CITY OF ALBUQUERQUE

January 4, 2012

Re: Monterey Baptist Church Grading and Drainage Plan
Engineer's Stamp date 12-20-11 (J22/D012A)

Site Grading and Drainage Plan

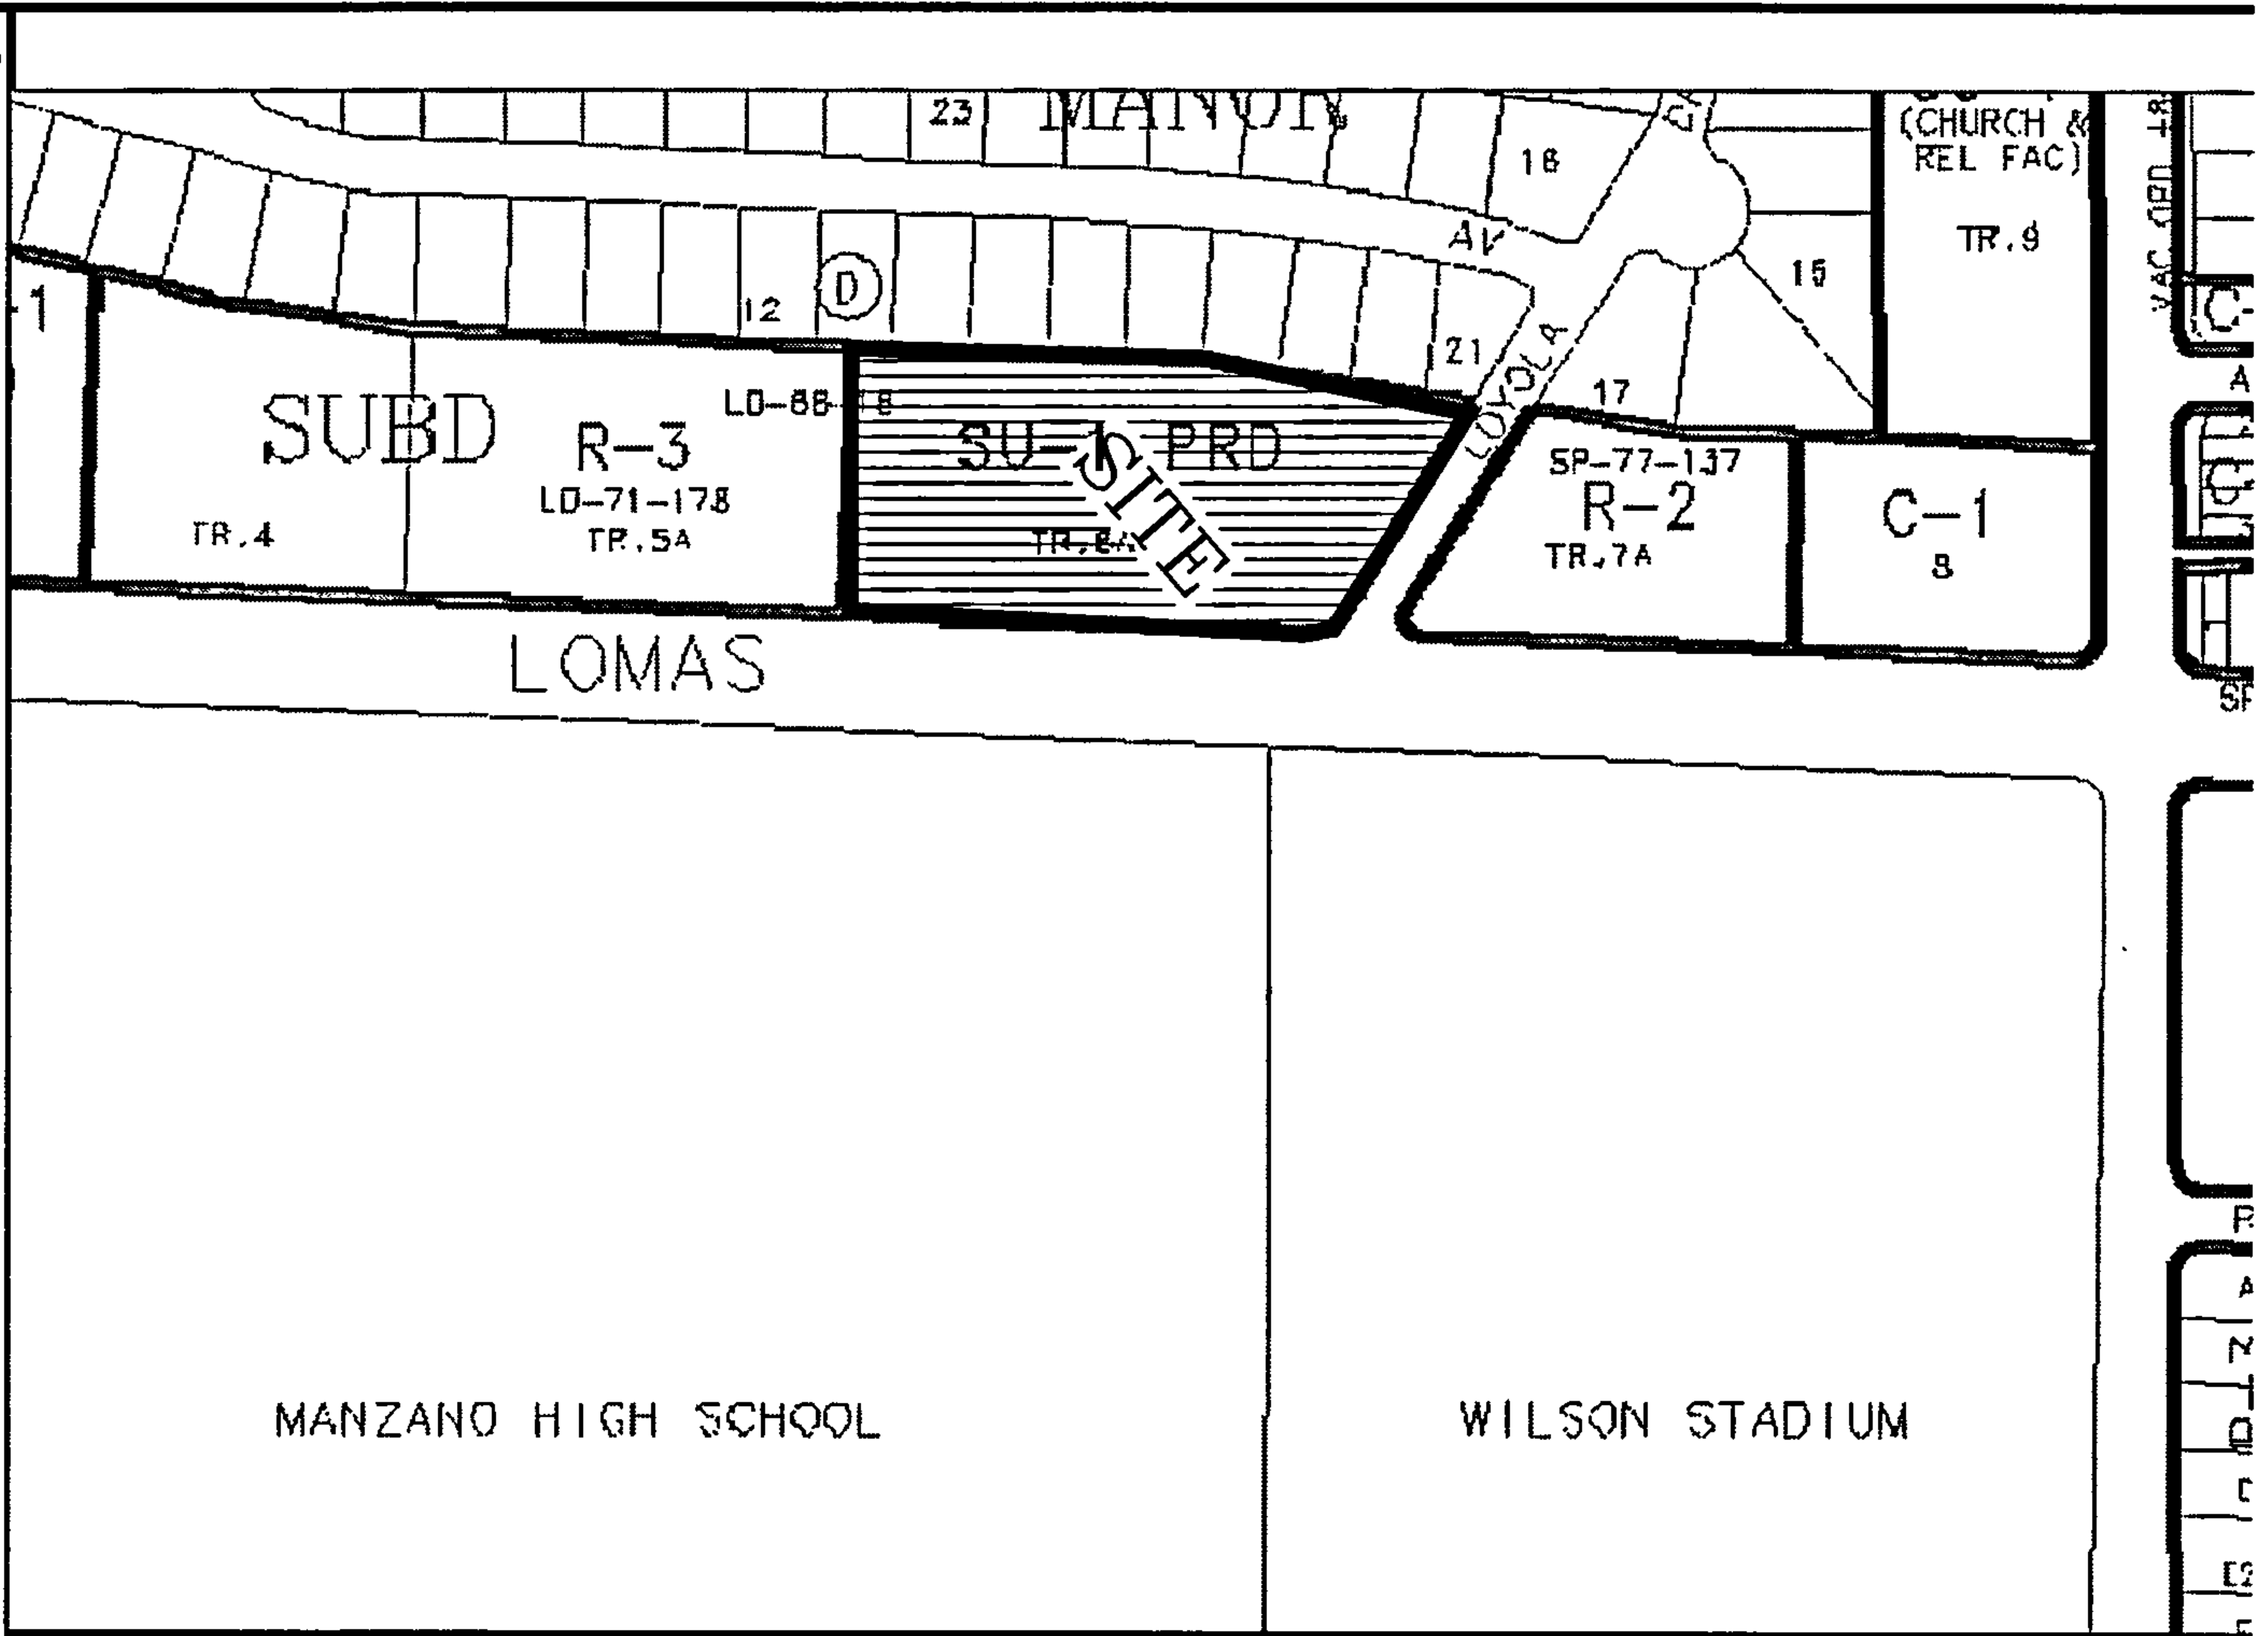
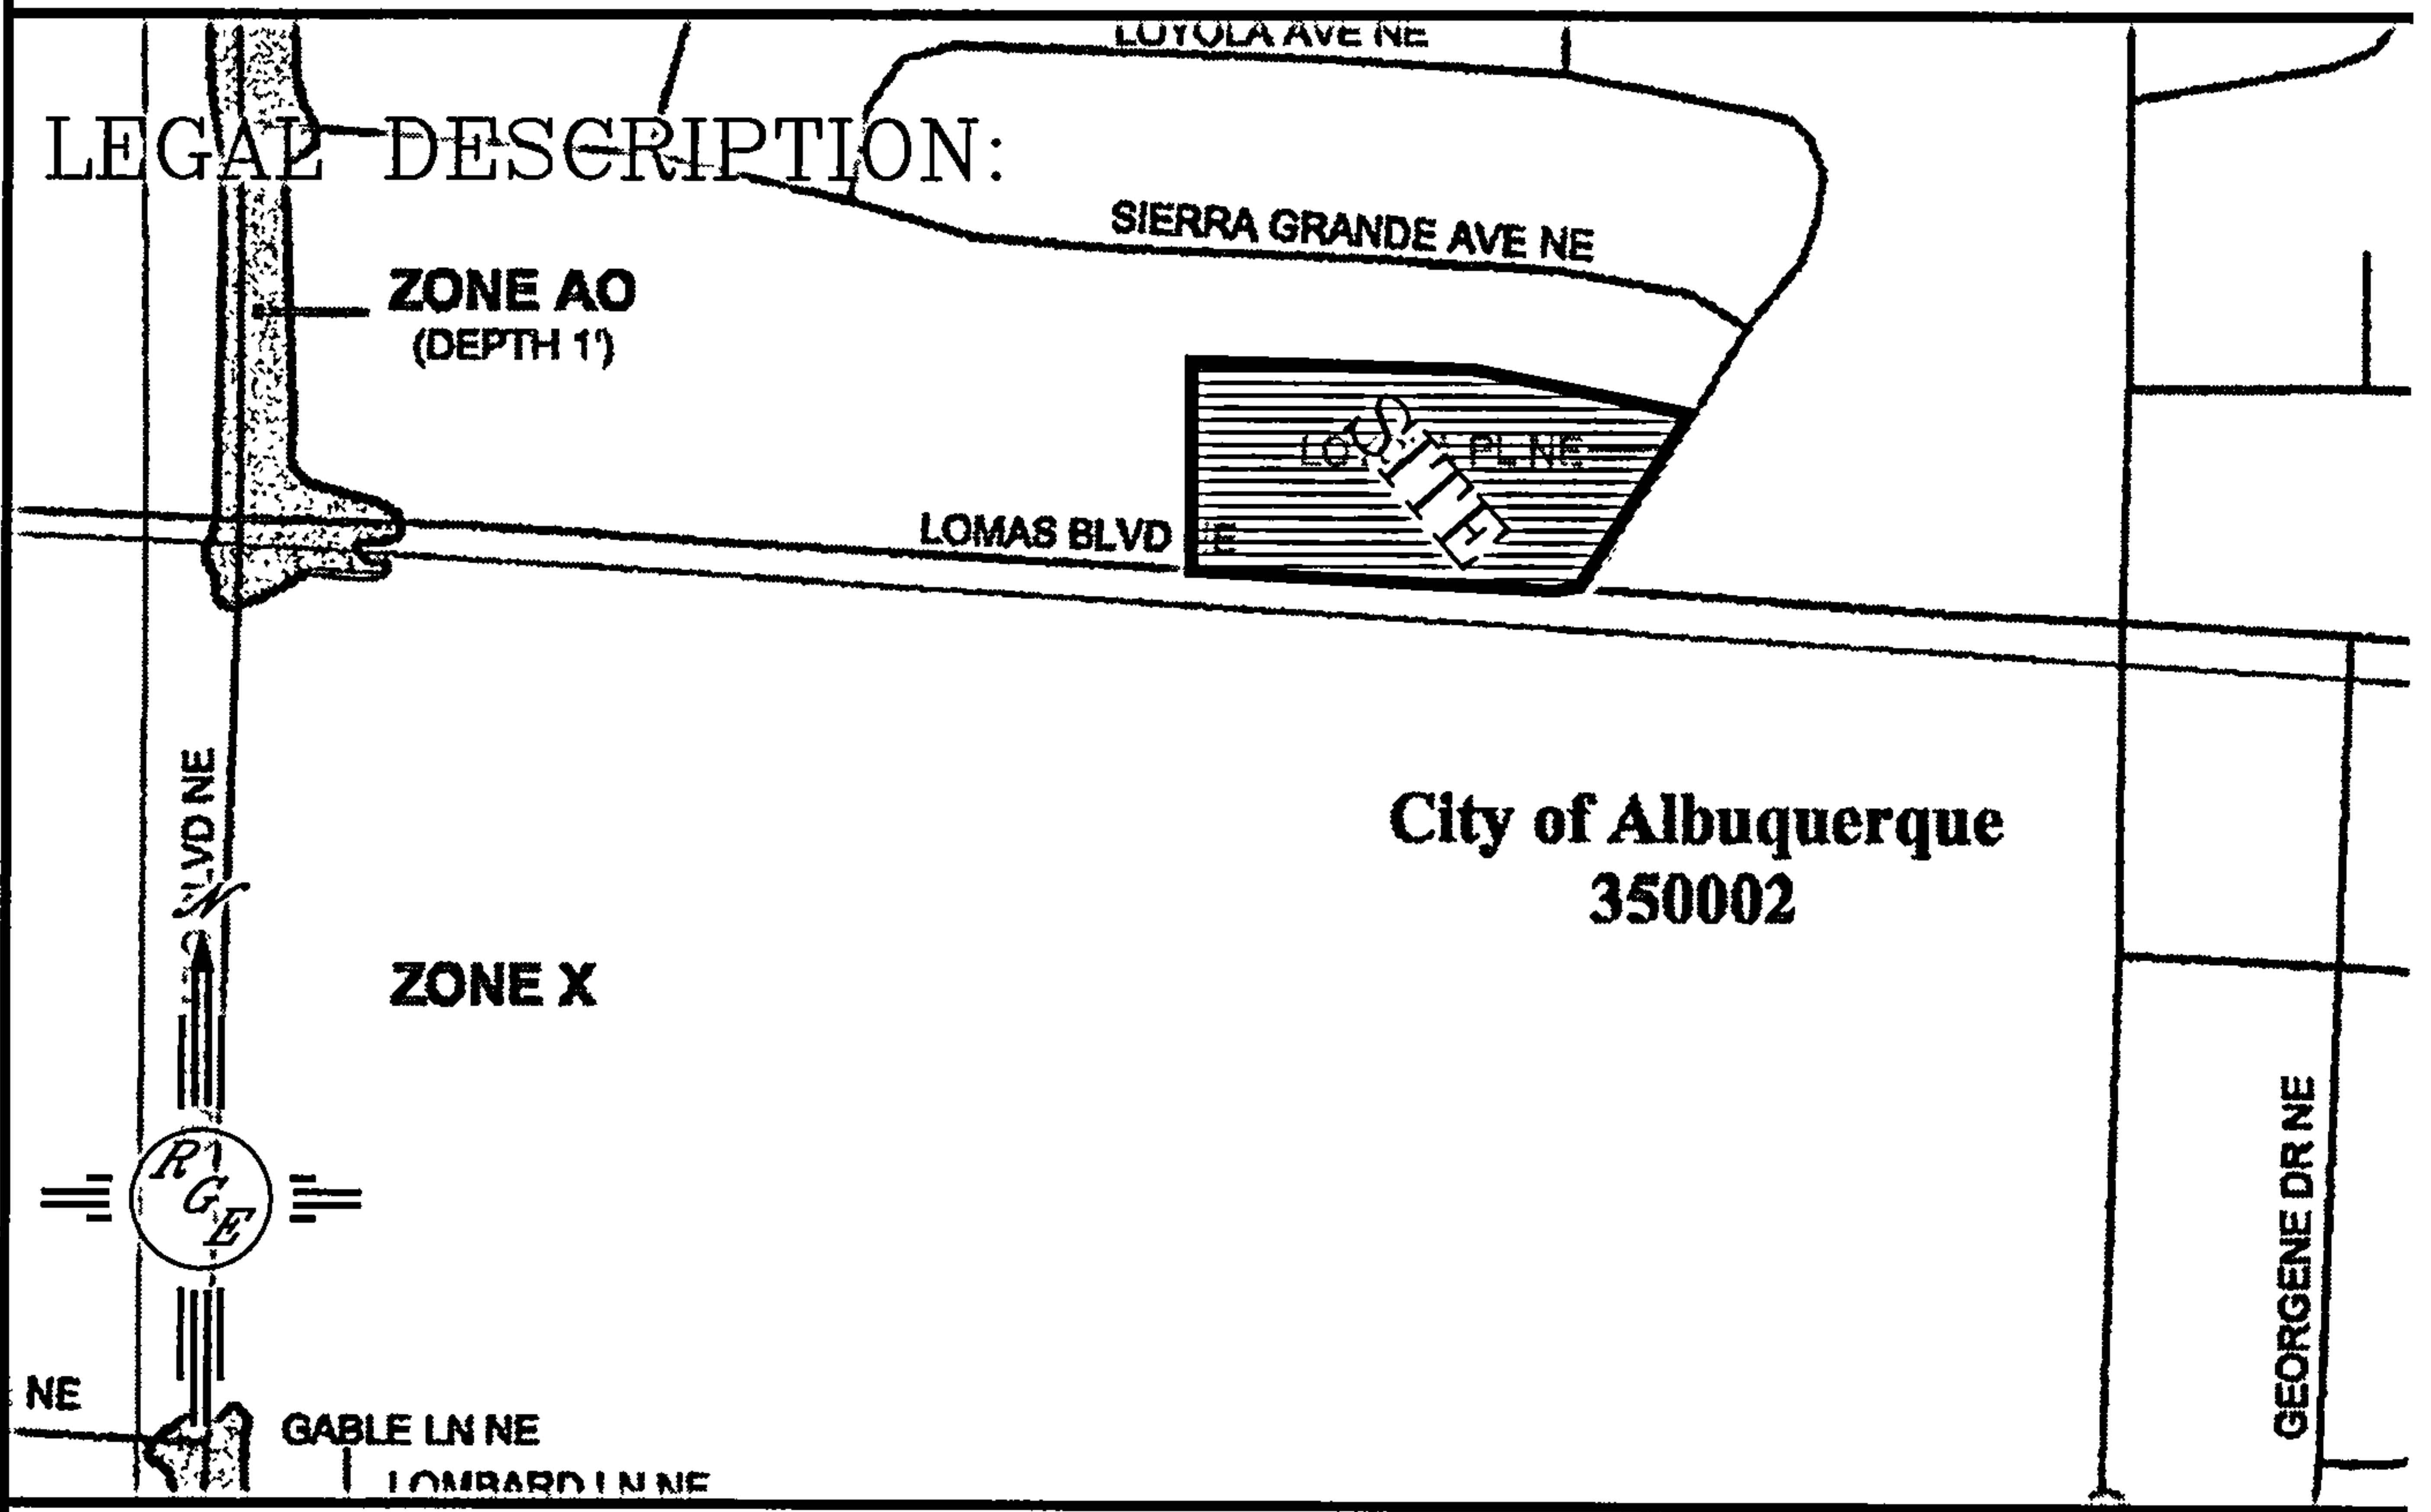
- Hydrology is recommending that both Basin A & Basin B be discharged into the detention pond on site.
- It appears that flows on the northern portion of Basin C will flow into Basin D, will a swale be used to direct these flows to the pond?
- The southern portion of Basin C also appears to flow across the sidewalk into Lomas Blvd., how will these flows be directed to the pond?
- Details will be needed on the pond's sidewalk culvert illustrating how the 8" HDPE pipe will drain into the 6" culvert.
- Will there be an emergency overflow for the retention pond?
- Please define the hatching adjacent to the existing asphalt paving (at the turnaround area).
- Hydrology requests that proposed landscape areas be depressed to retain/infiltrate the rain that falls on them.
